Our ref: RA/2022/145450/01
Your ref: EN010120
Date: 22 February 2023

DRAX POWER STATION BIOENERGY WITH CARBON CAPTURE AND STORAGE EXTENSION DEVELOPMENT CONSENT ORDER: RESPONSE TO EXAMINER'S QUESTIONS ExQ1

22 February 2023 – EN010120 Environment Agency response to ExQ1

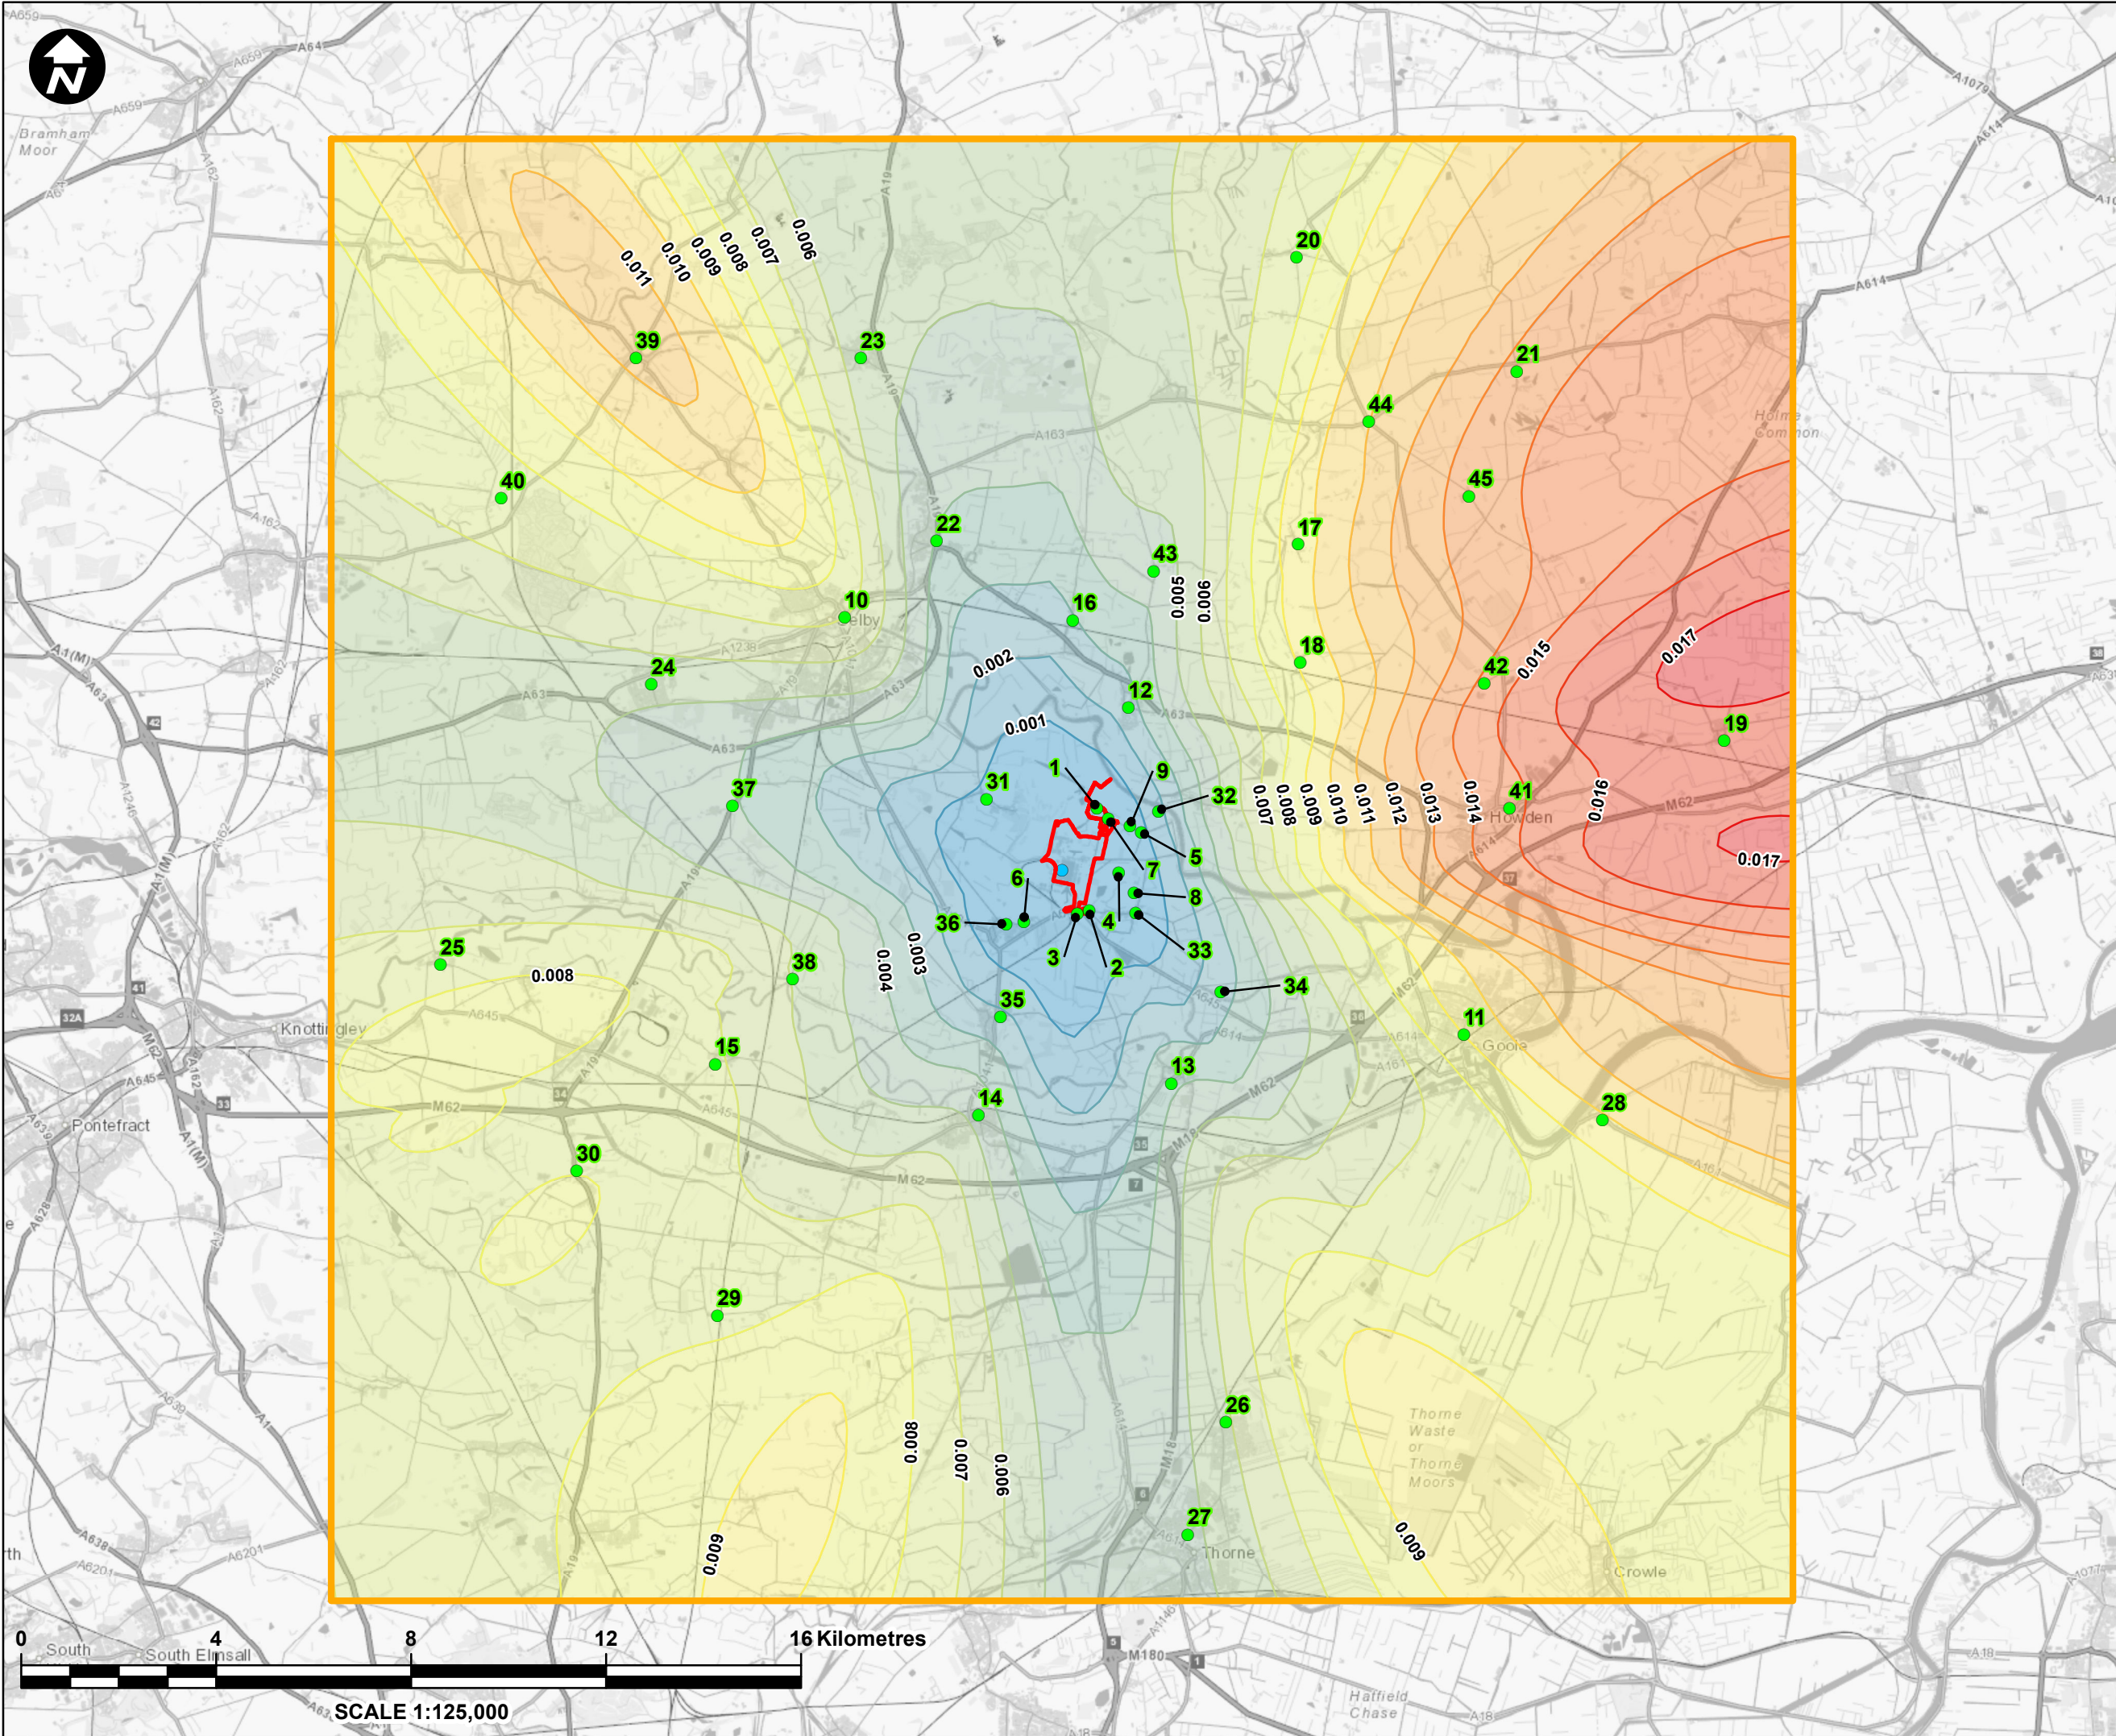
AQ.1.4	EA	<p>Figure 6.8 [APP-075] shows a significant area that would fall into the category of slight adverse impact ($\geq 6\%$ of EAL) for annual nitrosamines process contribution, and the dispersion pattern suggests that the area would extend beyond the study area.</p> <p>Does the EA consider the study area to be sufficient for the assessment of the impact of nitrosamines?</p>	<p>The applicant has applied to vary their existing Environmental Permitting Regulations (EPR) permit. We cannot provide comment on the air quality impact assessment made for planning purposes as that we be in effect 'pre-determining' the EPR application which we cannot do.</p> <p>Further detail on this is provided within our Written Representation.</p>
AQ.1.5	EA	<p>Is the EA satisfied that any potential uncertainties in the modelling of atmospheric degradation of amines has been addressed by the Applicant?</p>	<p>The applicant has applied to vary their existing Environmental Permitting Regulations (EPR) permit. We cannot provide comment on the air quality impact assessment made for planning purposes as that we be in</p>

ExQ1	Question to:	Question:	EA Response
			<p>effect 'pre-determining' the EPR application which we cannot do.</p> <p>Further detail on this is provided within our Written Representation.</p>
AQ.1.6	Applicant		-
AQ.1.7	EA/ SDC	<p>Can the EA and SDC confirm that they are satisfied with the Applicant's approach of undertaking no additional project-specific air quality surveys as per paragraph 6.5.49 of the ES [APP-042]?</p>	<p>The applicant has applied to vary their existing Environmental Permitting Regulations (EPR) permit. We cannot provide comment on the air quality impact assessment made for planning purposes as that we be in effect 'pre-determining' the EPR application which we cannot do.</p> <p>Further detail on this is provided within our Written Representation.</p>
AQ.1.8	Applicant		-
AQ.1.9	EA	<p>ES Chapter 6 [APP-042] explains that it was not considered appropriate to undertake modelling of cumulative impacts associated with amine compounds due to uncertainty in amine chemistry methodology and conservatism in modelling for proxy compounds. Instead, an approach was taken whereby the maximum predicted MEA and NDMA concentrations from both the Proposed Development and the Keadby 3 assessments were summed and compared to the respective EALs.</p> <p>Please can the EA provide its view of this approach.</p>	<p>We cannot provide comment on the air quality impact assessment made for planning purposes as that we be in effect 'pre-determining' the EPR application which we cannot do. Once the application has been duly made we will then begin a detailed determination of the application. We will assess the Applicant's air quality impact assessment and whether it is / is not appropriate to model cumulative impacts associated with amine compounds. That will involve the air quality impact assessment being fully reviewed by our Air Quality and Modelling Assessment Unit.</p>
